KITTITAS COUNTY FIRE MARSHAL'S OFFICE

Re: Anderson (BL-15-00016)

Upon review of the above mentioned land use action, I have the following comments/requirements;

ANDERSON PROPERTY

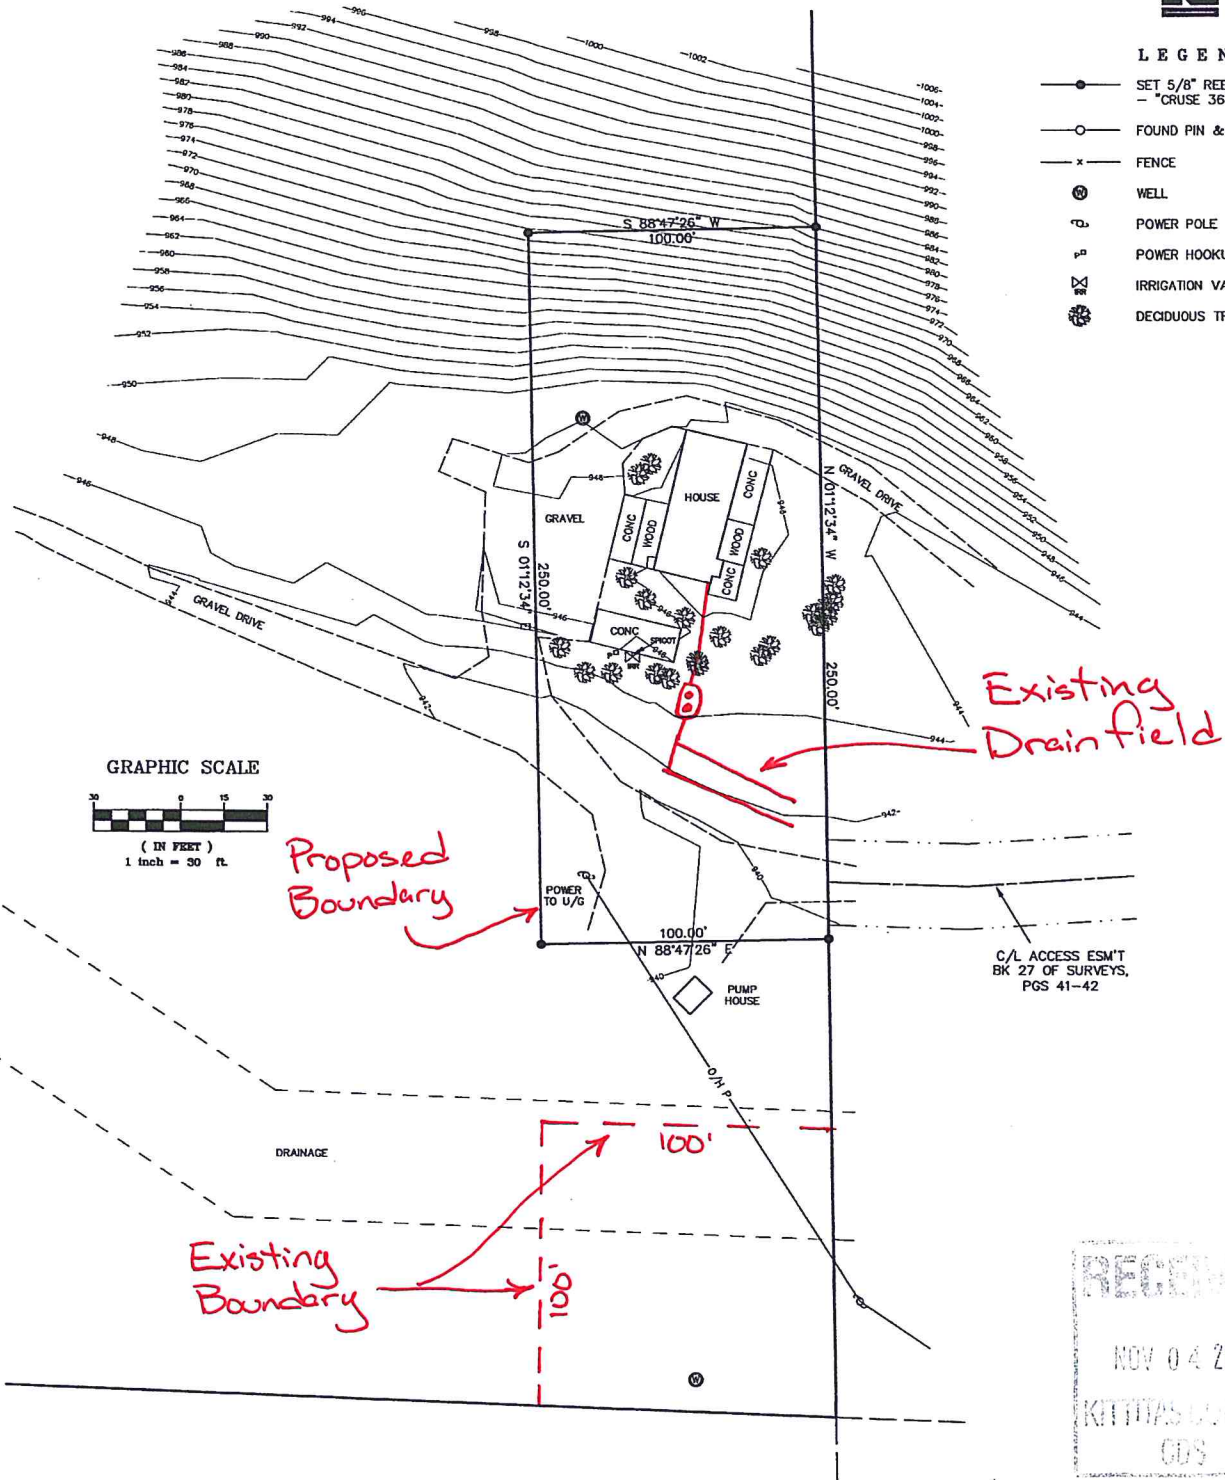
- Ensure that boundary line adjustments do not infringe upon existing structures, to include propane tanks, etc.
- Ensure adequate access for fire apparatus. Any driveways or access points created based off the new lot configurations shall comply with Kittitas County Code 20.02.030.
- All future development must comply with the International Fire Code.
